City of Portland, Maine - Building or Use Permit

Proposed Use: Six (6) Family Residential Combine 3rd floor egress with 1st & 2nd floor egress and remove existing fire escape	Proposed Project Description: Combine 3rd floor egress with 1st & 2nd floor egress and remove existing fire escape
--	---

**PUBLIC HEARING
170-172 CLARK STREET**

Application For: Certificate of Appropriateness – Modifications to Rear Egress

EXISTING FOOTPRINT

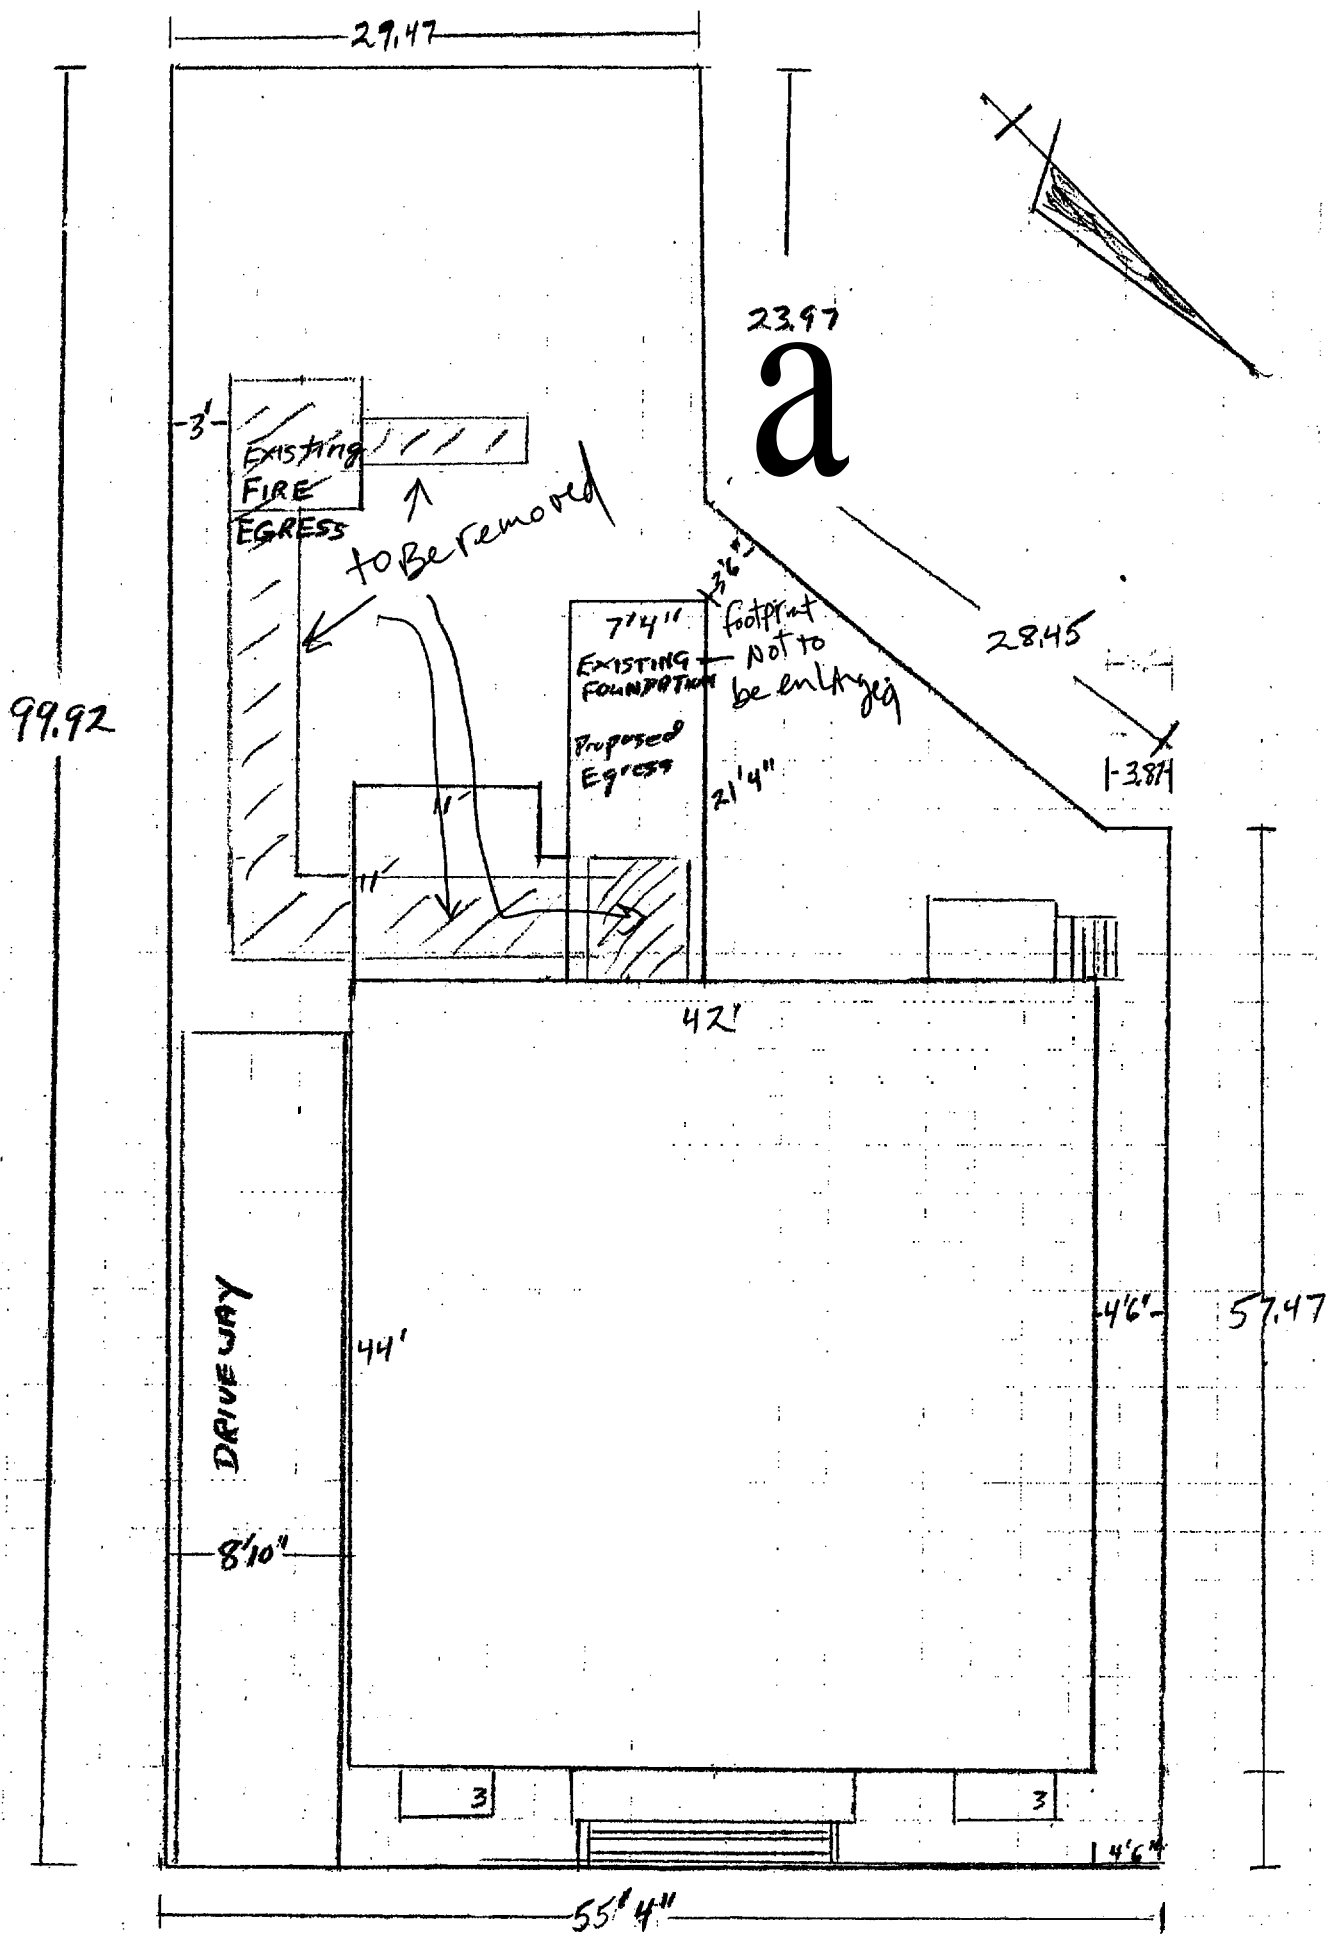
Note: 6/6/06 Spoke with Bill Getz - there is no increase in the existing footprint - the existing egress will go up one more story with a shed dormer **Ok to Issue:**

INTERIOR VIEW
OF COMBINED
STAIR ADDITION

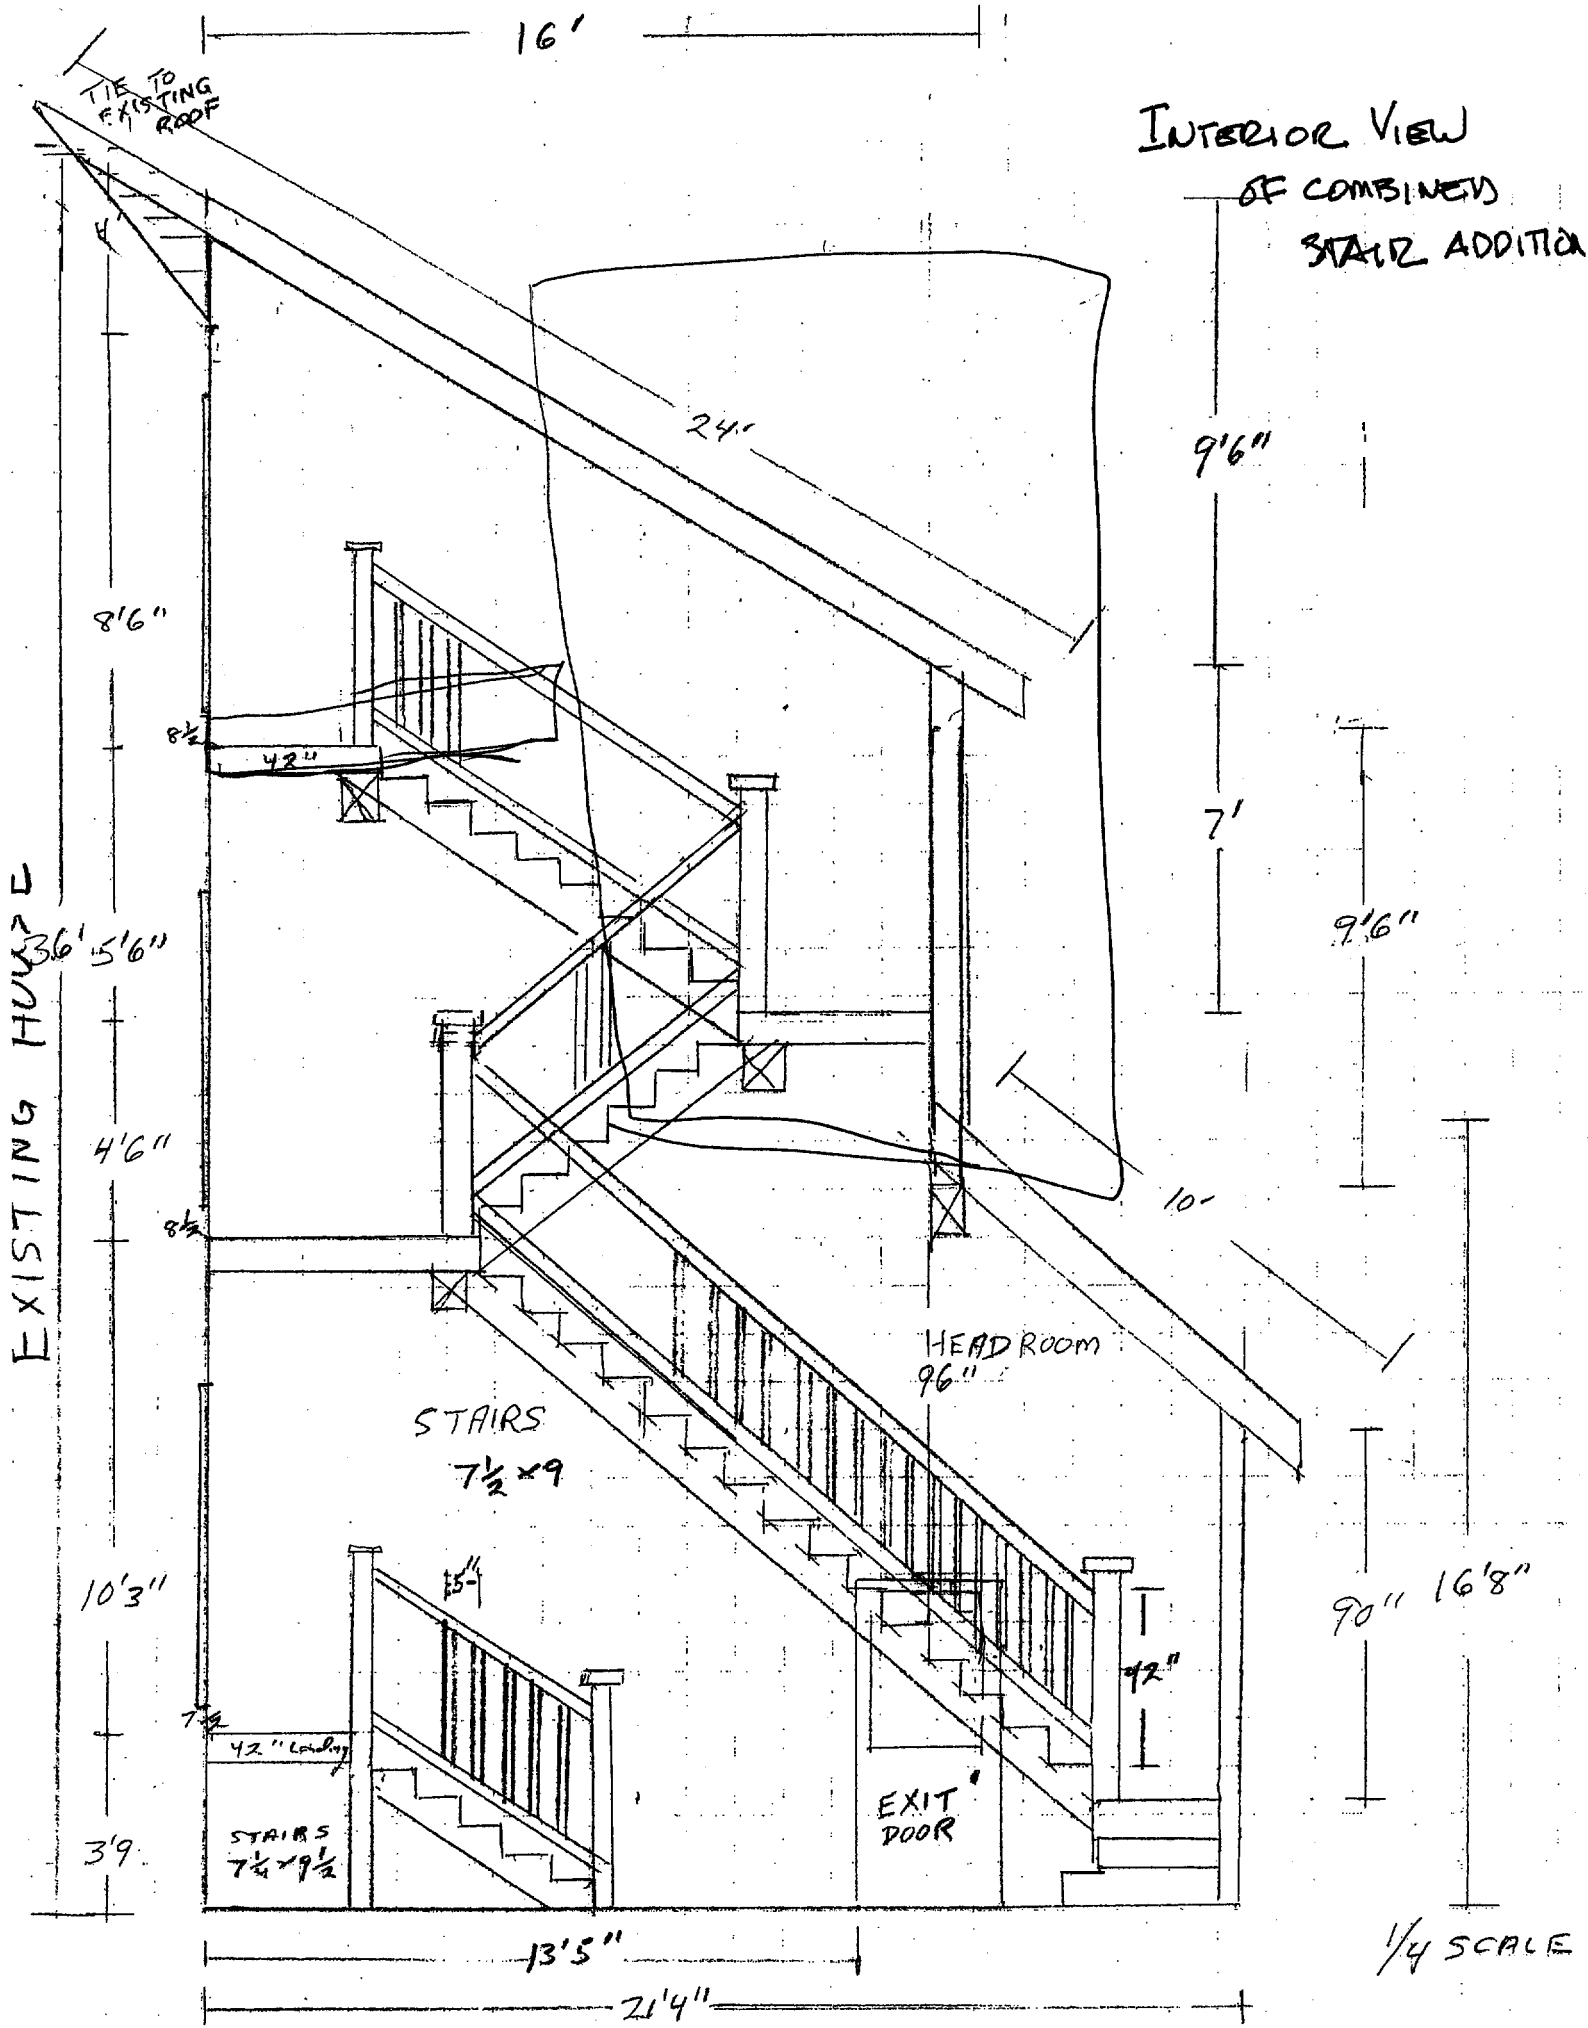
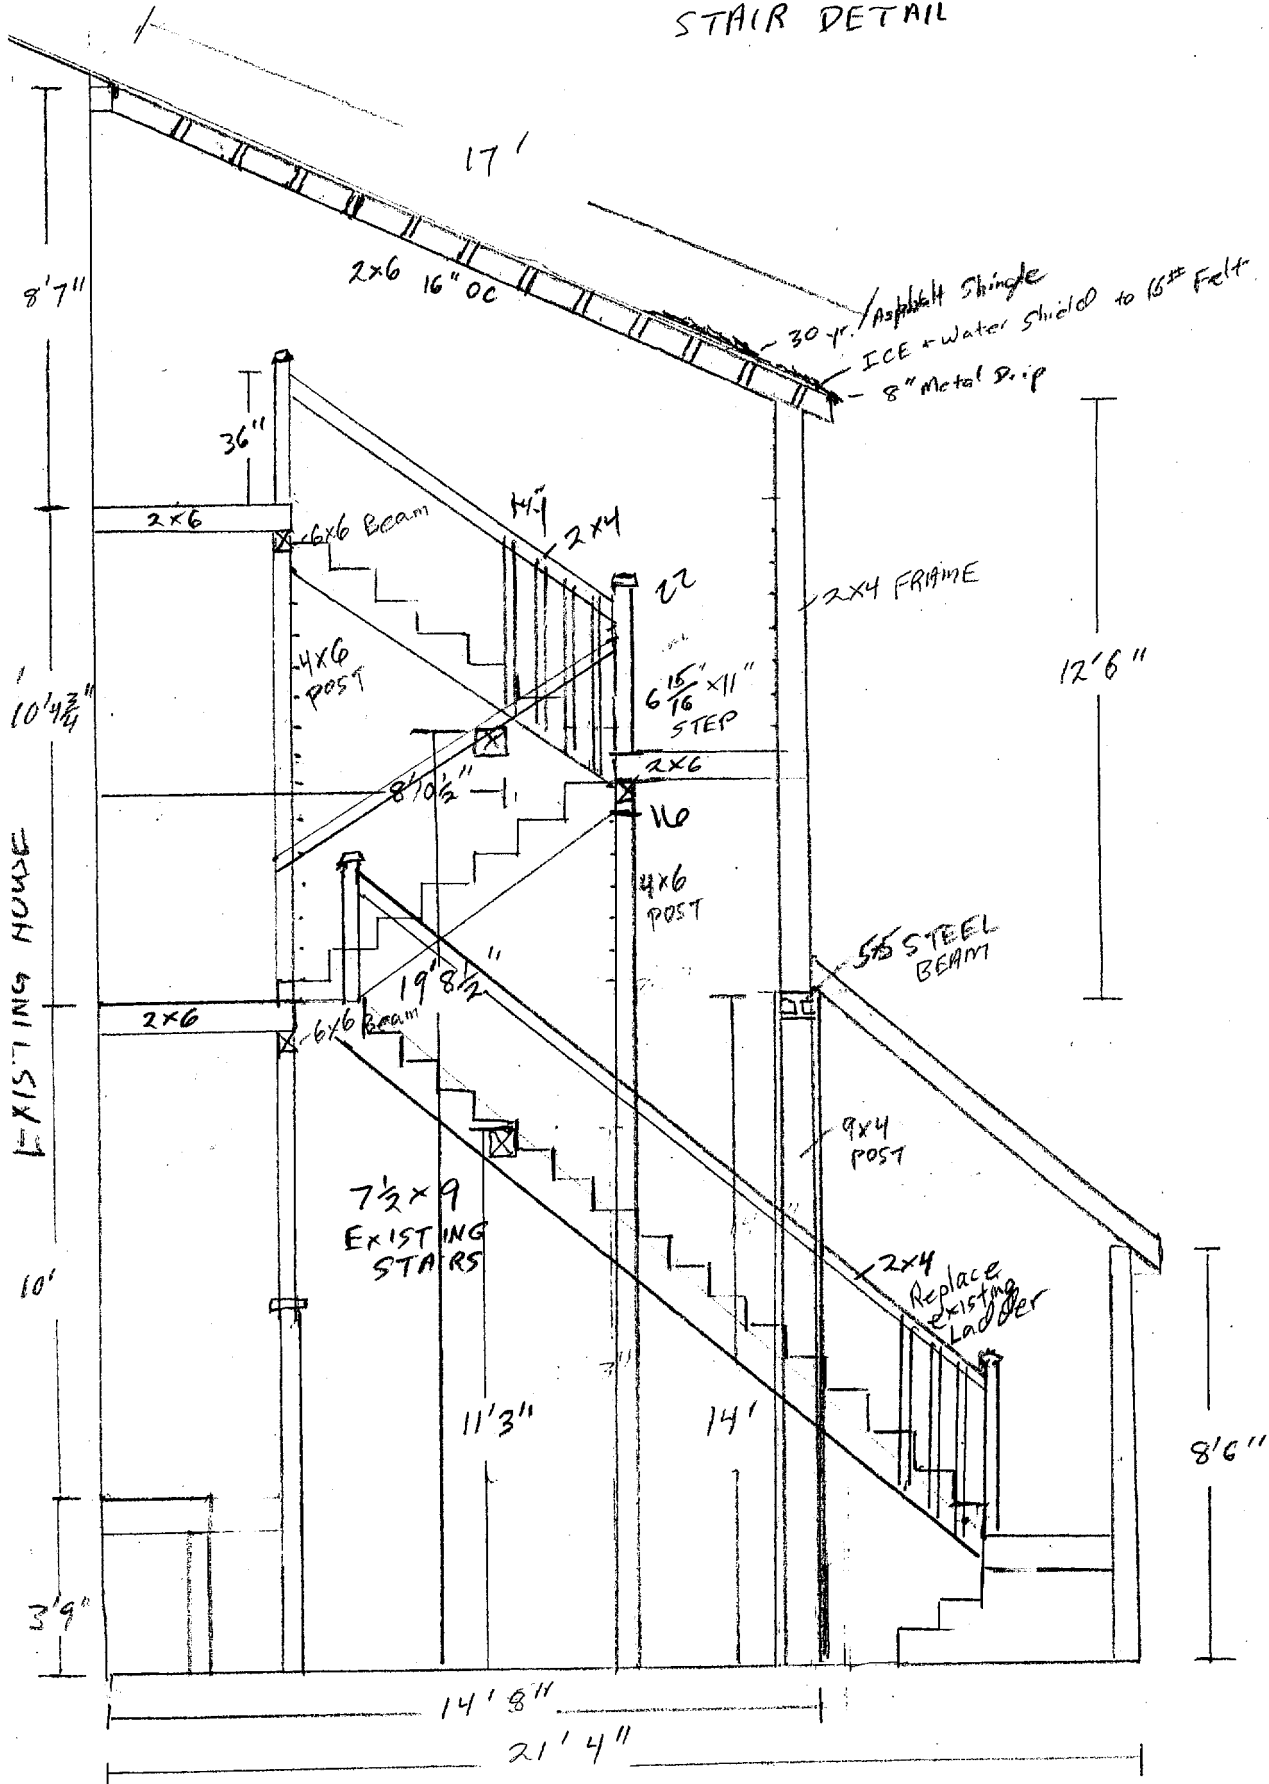
- 1) Window on rear elevation of addition to be 2 over 1 to match windows of house, size to be adjusted, proportions to be followed.
- 2) All details and materials of addition to match those of existing house.
- 3) Addition roofline to match existing dormer roof slope if at all possible, extended in a contious line from dormer roof.

- 1) 1009.11 Handrails.
Stairways shall have handrails on each side. Handrails shall be adequate in strength and attachment in accordance with Section 1607.7.

- 3) 1009.1 Stairway width.
The width of stairways shall be determined as specified in Section 1005.1, but such width shall not be less than 44 inches (1118 mm). See Section 1007.3 for accessible means of egress stairways.
Exceptions:

1. Stairways serving an occupant load of 50 or less shall have a width of not less than 36 inches (914 mm).
- 4) 1009.2 Headroom.
Stairways shall have a minimum headroom clearance of 80 inches (2032 mm) measured vertically from a line connecting the edge of the nosings. Such headroom shall be continuous above the stairway to the point where the line intersects the landing below, one tread depth beyond the bottom riser. The minimum clearance shall be maintained the full width of the stairway and landing.

Stair riser heights shall be 7 inches (178 mm) maximum and 4 inches (102 mm) minimum. Stair tread depths shall be 11 inches (279 mm) minimum. The riser height shall be measured vertically between the leading edges of adjacent treads. The greatest riser height within any flight of stairs shall not exceed the smallest by more than 0.375 inch (9.5 mm). The tread depth shall be measured horizontally between the vertical planes of the foremost projection of adjacent treads and at right angle to the tread's leading edge. The greatest tread depth within any flight of stairs shall not exceed the smallest by more than 0.375 inch (9.5 mm).
